KIRKLEES METROPOLITAN COUNCIL INVESTMENT & REGENERATION SERVICE

DELEGATED DECISION TO DETERMINE APPLICATIONS FOR CONSENT, AGREEMENT OR APPROVAL REQUIRED BY CONDITION

Reference No:	2025/44/90096/E
Site Address:	Land at, Blue Hills Farm, Whitehall Road West, Birkenshaw, BD11 2DU
Description:	Discharge of details reserved by condition 19 (PROW) of previous Reserved Matters approval 2022/91047 for a development of 91 dwellings, pursuant to outline permission 2019/90527 (for erection of up to 127 dwellings, with details of access)
Recommending Officer:	Victor Grayson

Discharge of details reserved by condition 19 (PROW) of previous Reserved Matters approval 2022/91047 for a development of 91 dwellings, pursuant to outline permission 2019/90527 (for erection of up to 127 dwellings, with details of access)

Management Company
Conveyance Plan
Blue Hills Estate Farm
Birkenshaw

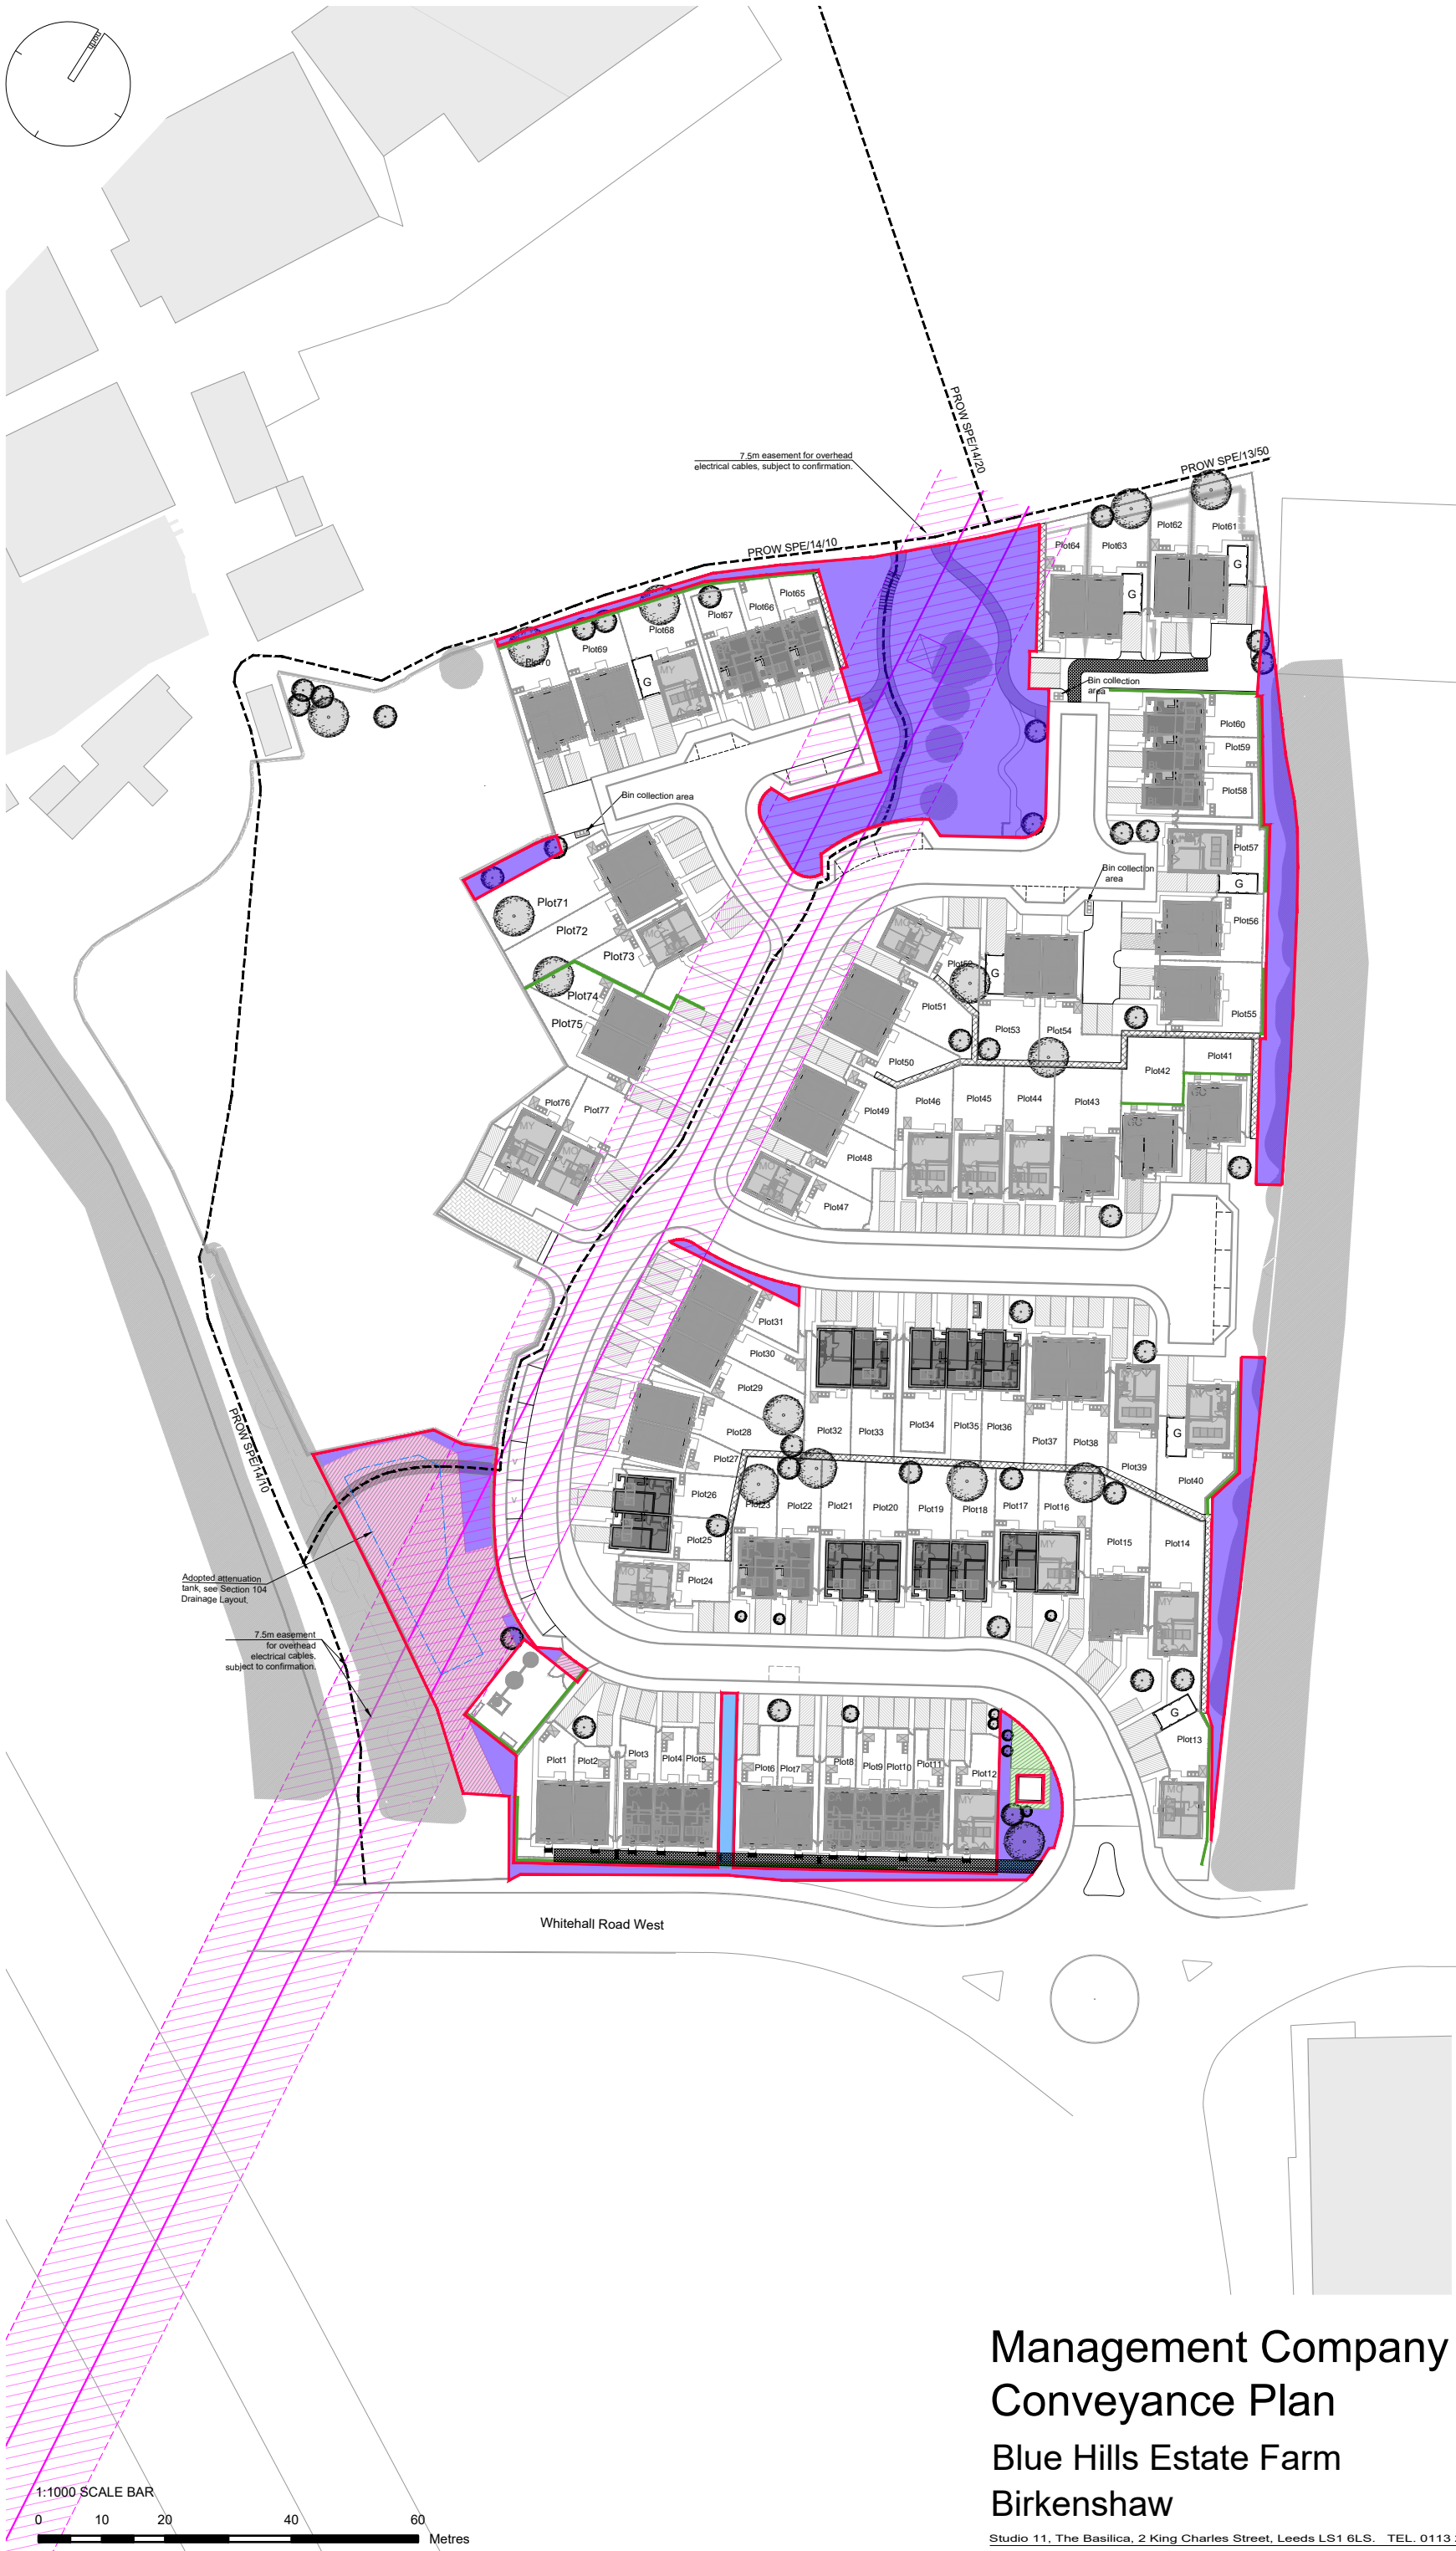
05/06/2025 – Amendments needed. Timber stakes would not be long-lasting. Steps should be anchored using rebar drilled through the sleepers. Wooden handrails do not last and can cause splinters – painted keyclamp handrails would be the best option. Also query how path through the public open spaces would be dealt with in terms of dedication and adoption.

Condition 19 also requires an ongoing management and maintenance plan of the new public right of way through the site. The submitted drawing 4035.20.390 rev P6 confirms that, where the new public right of way passes through the development's public open spaces (at the north end and western edge of the site), it would be maintained by the Management Company. The Submitted Landscape Management Plan states:
